From: Pendry, Glenn [REDACTED]
Sent: 23 July 2020 07:59
To: Anita Gardner <Anita.Gardner@arun.gov.uk>
Cc: 'Lynnette St quintin' [REDACTED]
Subject: AB/63/20/DOC 74-76 Canada Road

From: Laura Gibbons <>
Sent: 21 July 2020 15:34
To: Planning.Responses <Planning.Responses@arun.gov.uk>
Cc: Anita Gardner <Anita.Gardner@arun.gov.uk>
Subject: AB/63/20/DOC

We have the following comments regarding condition 9:

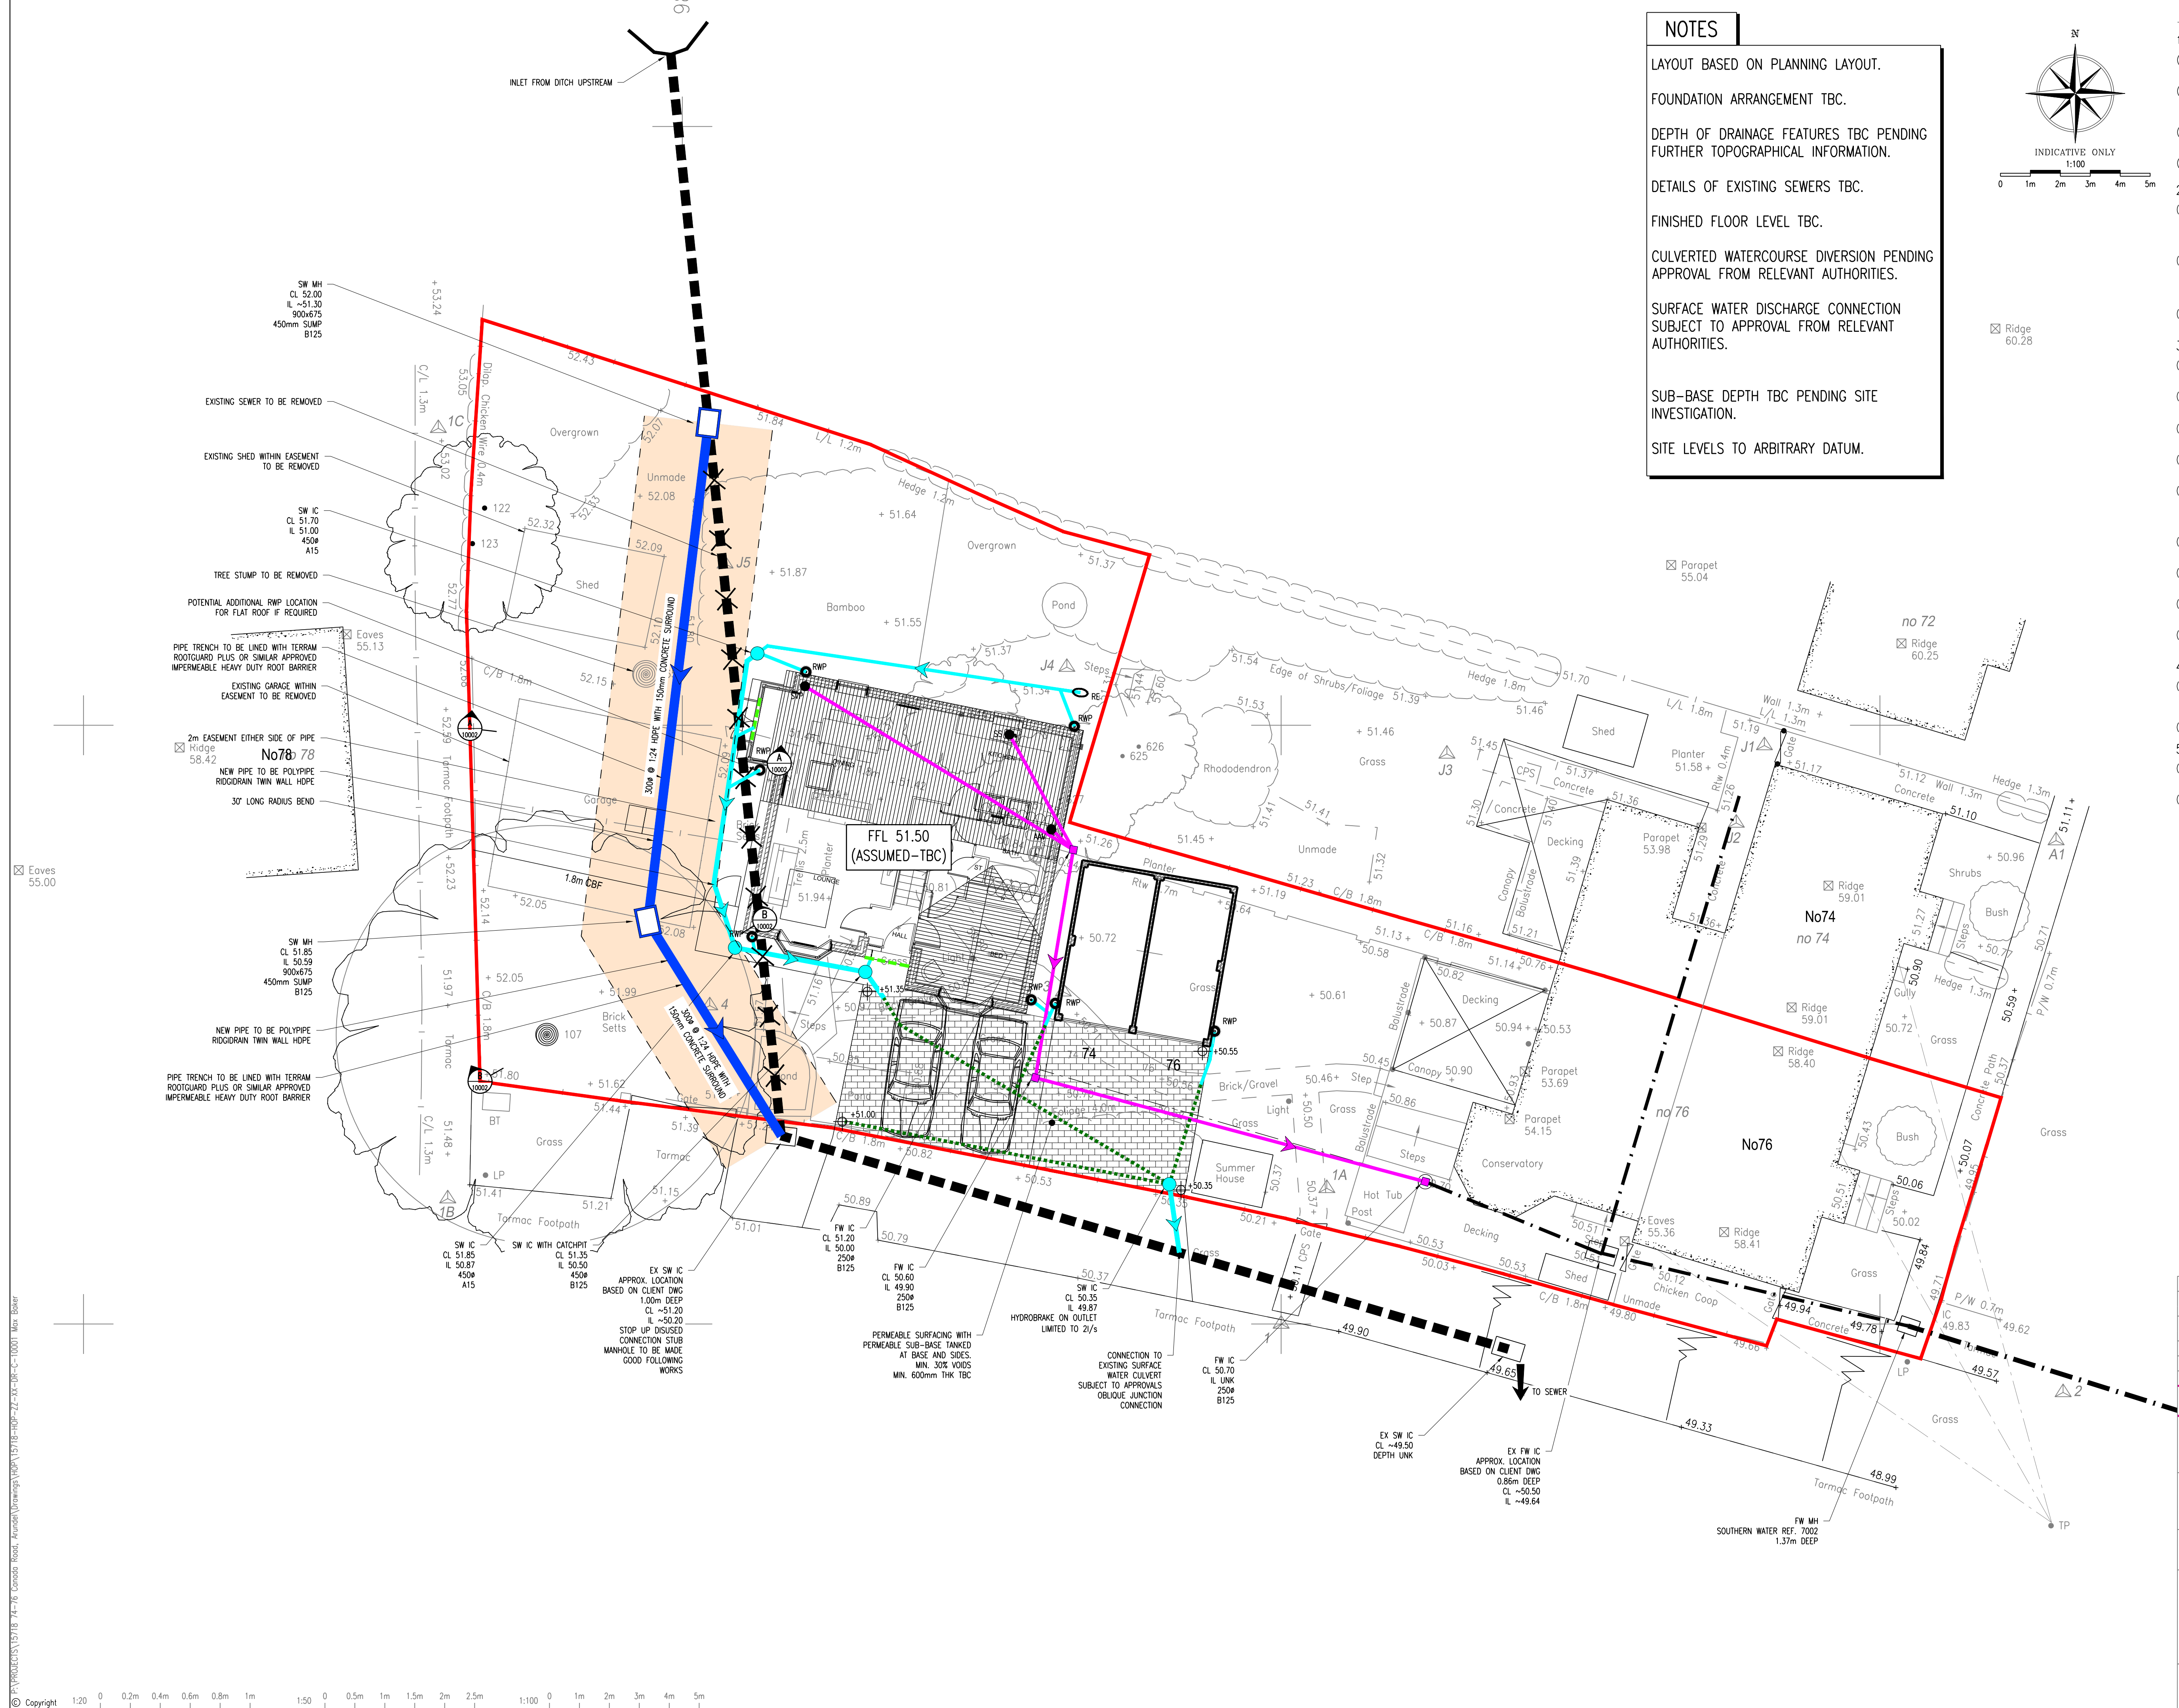
1. Please can a site specific construction detail drawing of the hydrobrake be provided.
2. Please adjust layout to include silt traps prior to all connections to permeable paving on plan.
3. Please provide finish and formation levels of permeable paving.
4. Please provide dimensions and construction detail for permeable pipe through sub-base.

Following on from our exchange of e-mails below, please find attached an updated copy of the engineer's drawings/details for review by you and your Drainage Engineer.
